Ref: SSD-79261463

**RE: SUBMISSION TO SSD-79261463 FOR RESIDENTIAL FLAT BUILDING WITH INFILL
AFFORDABLE HOUSING AT 2-4 WOODSIDE AVENUE & 1-3 REID STREET, LINDFIELD**

Ku-ring-gai Council's objection to SSD-79261463 at 2-4 Woodside Avenue & 1-3 Reid Street, Lindfield

PLANNING ENVELOPE - HOB

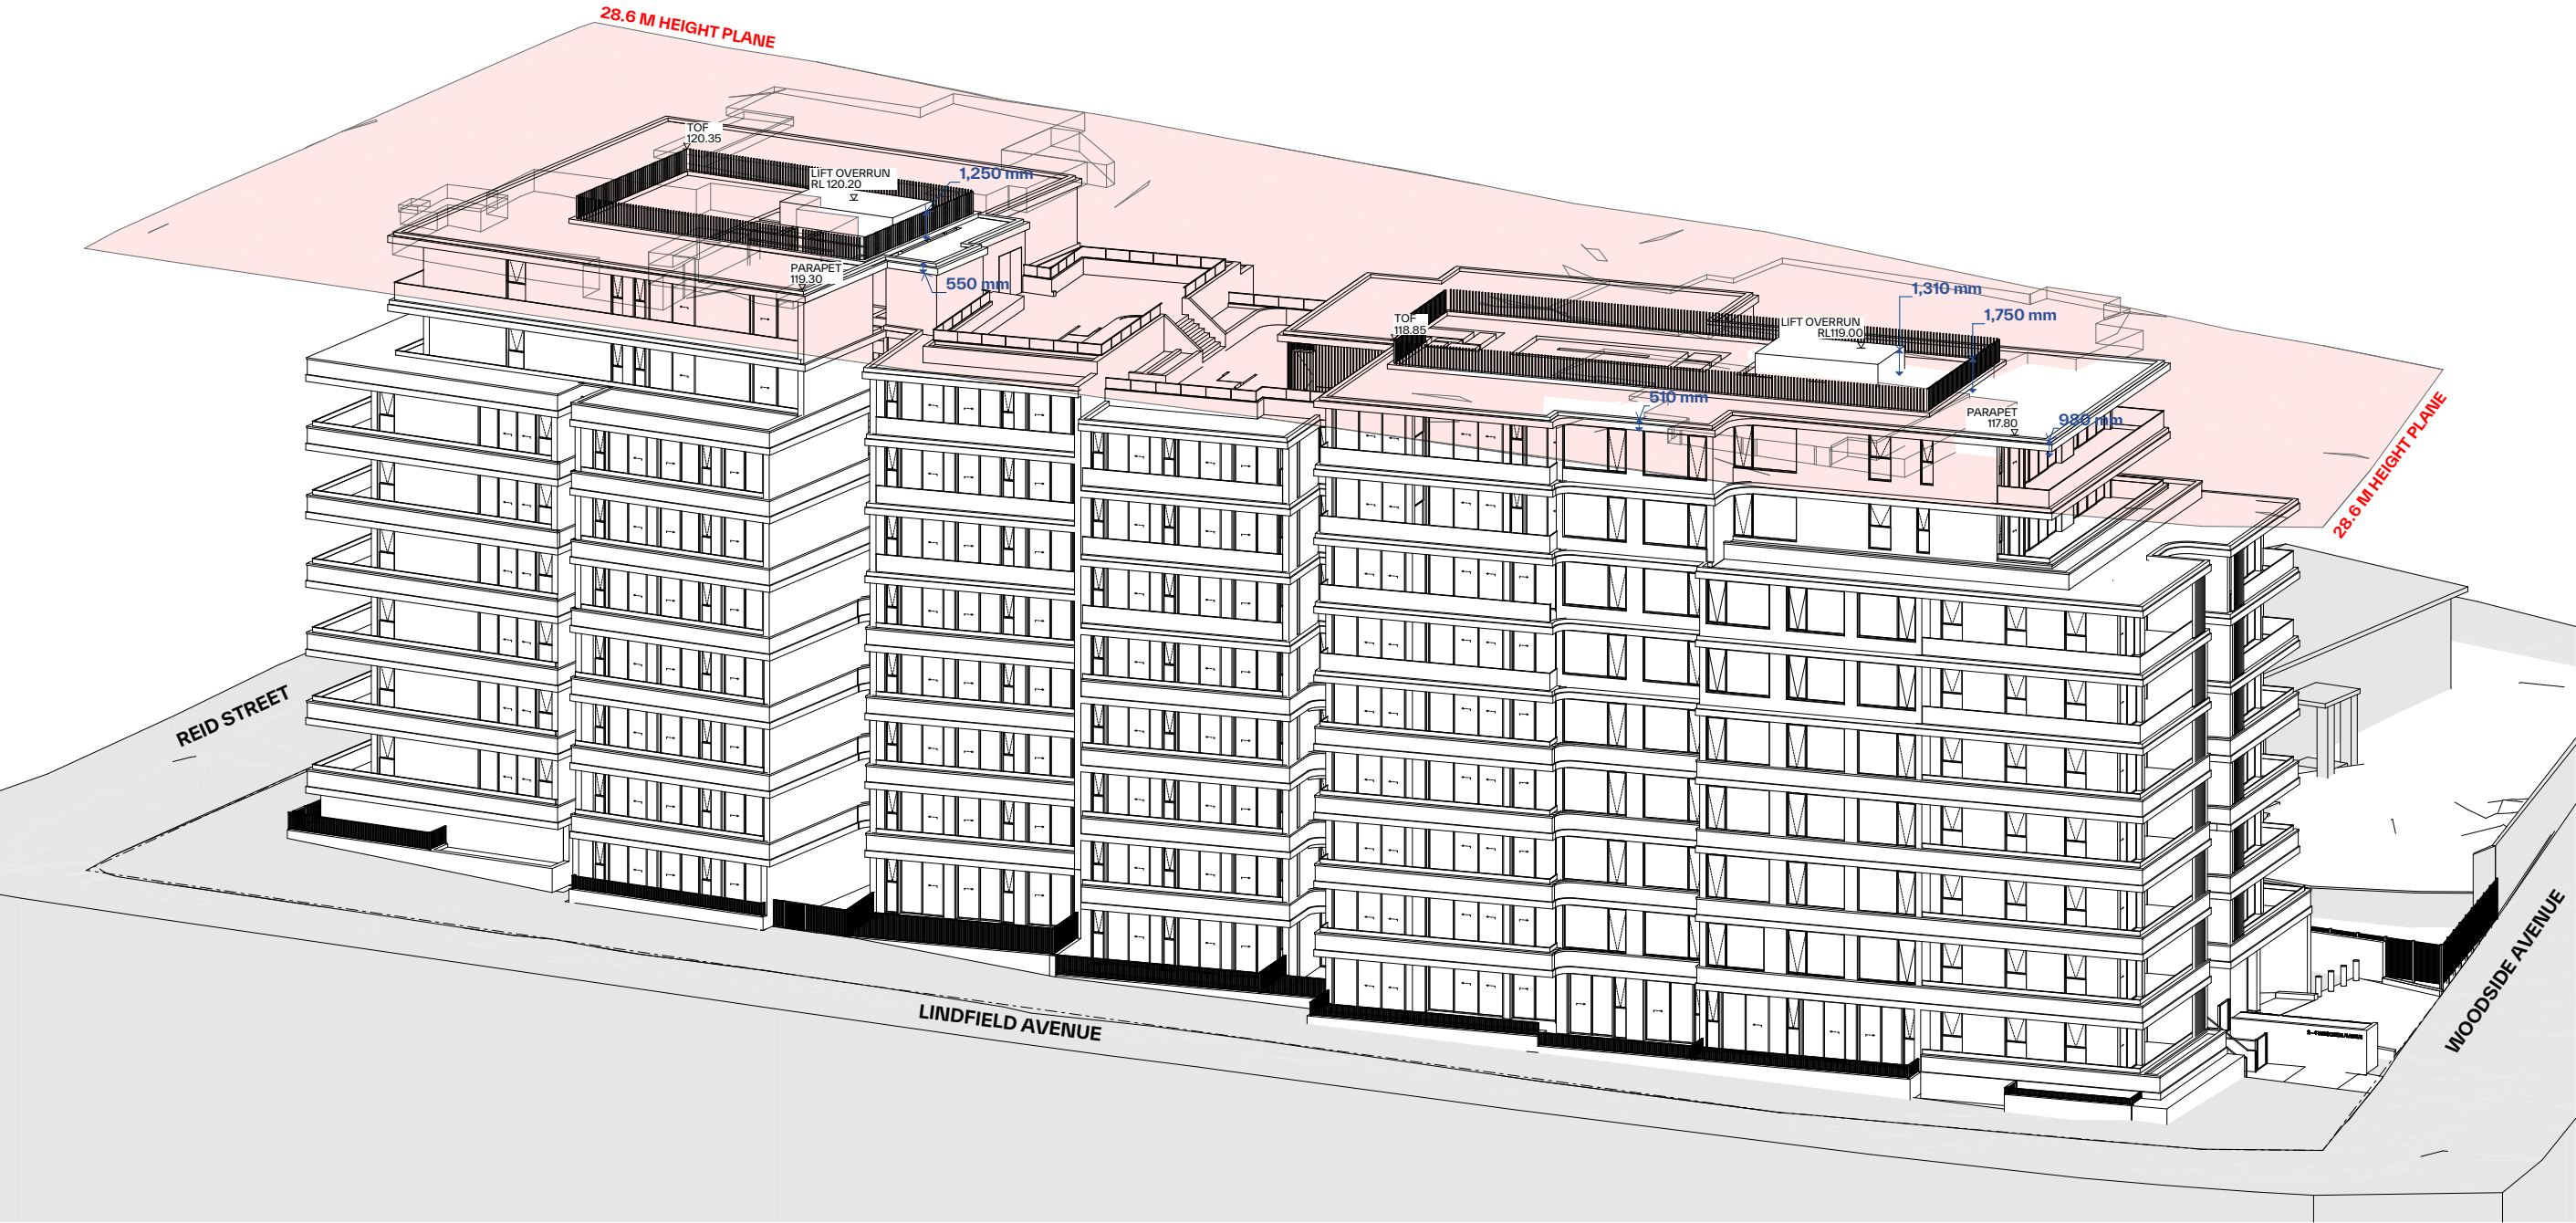
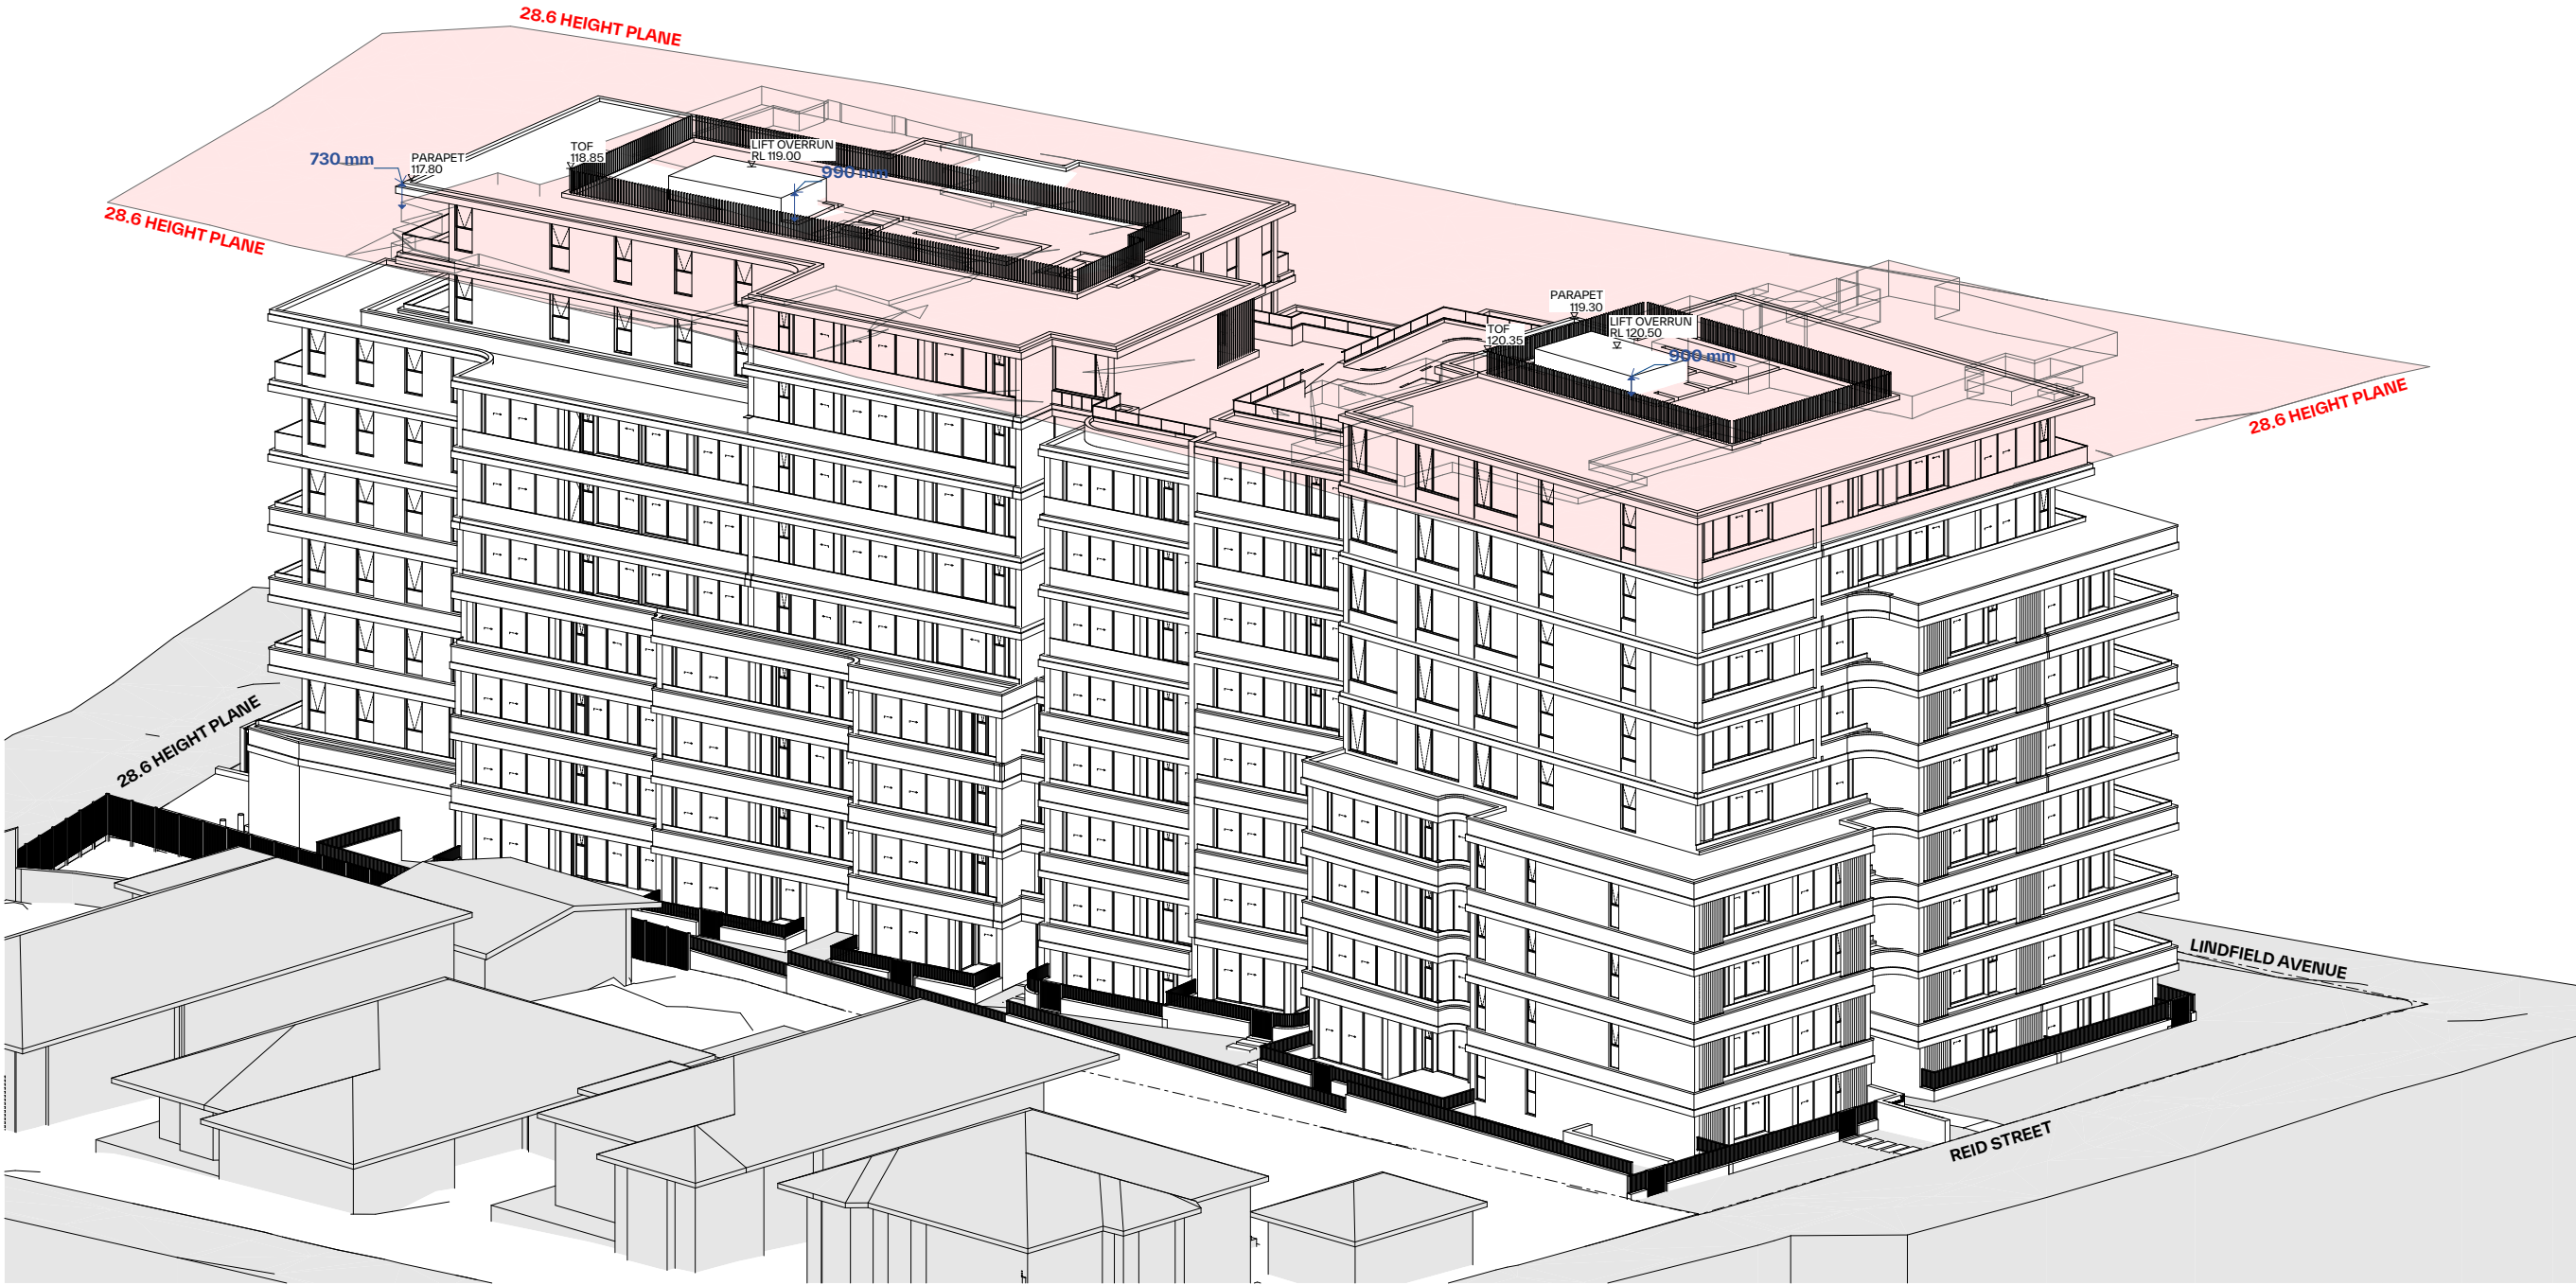
The proposed development seeks a variation to the maximum height of 28.6m permitted under Sections 18 (2) and 155(2) of the Housing SEPP. According to the Applicant, the proposed maximum building height is 30.35m which exceeds the height development standard by 1.75m (6.1% variation).

Furthermore, part of the building which breaches the height of building standard does not comply with the required building separation setback specified in the ADG.

LEVEL 1 PLAN

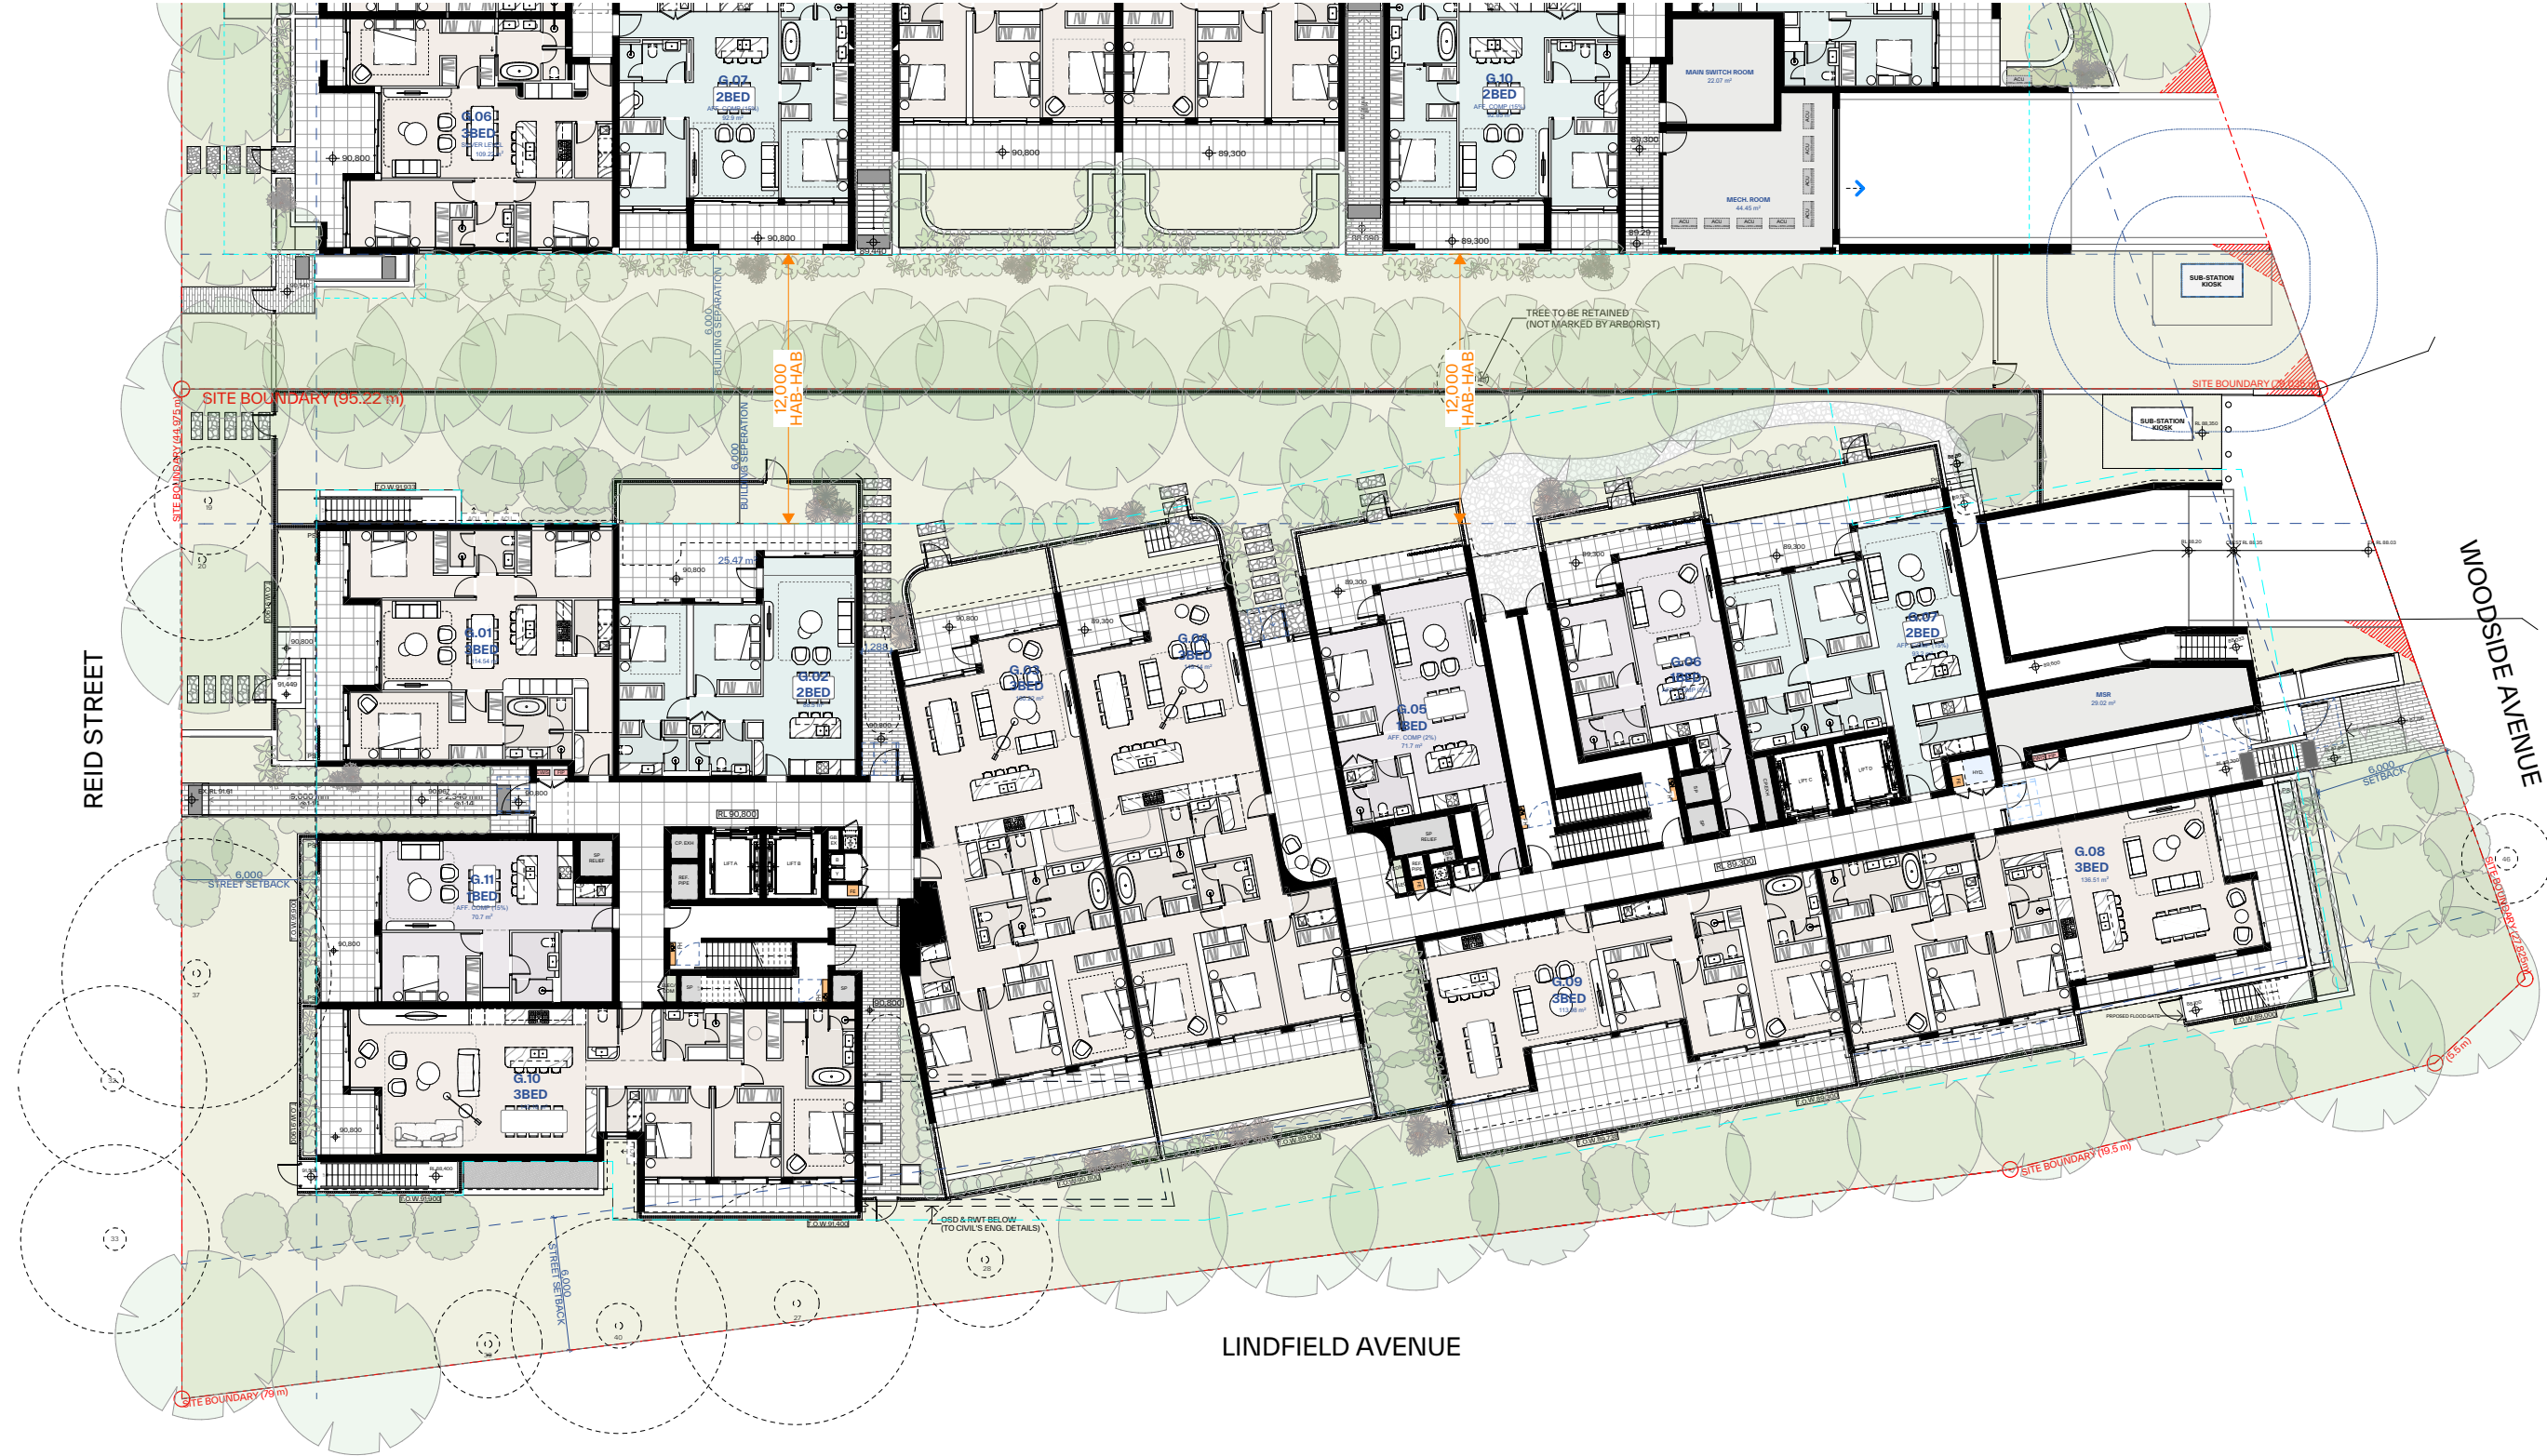
Furthermore, the design of the building results in the apartments in the middle of the building having a depth of approximately 19.36m which exceeds the maximum apartment depth of 12-18m recommended in Part 2E of the ADG:

Figure 8: Centre apartments with non-compliant depth (repeated layout from ground level to Level 7)

- Reduce the FSR to an amount which allows for fully compliant 6m setbacks (including basement) from the street frontages and ADG compliant setbacks from the rear boundary (as specified in Part 3F). This could be potentially achieved by reducing the depth of the building.
- Provide a minimum setback of 2.4m of the top storey from the outer face of the floors below on all sides in accordance with Part 7C.8 of KDCP.
- Reduce the building height to comply with the maximum permitted height.
- Provide a compliant amount of deep soil (Refer to Section F 'Landscaping and Tree Impacts').
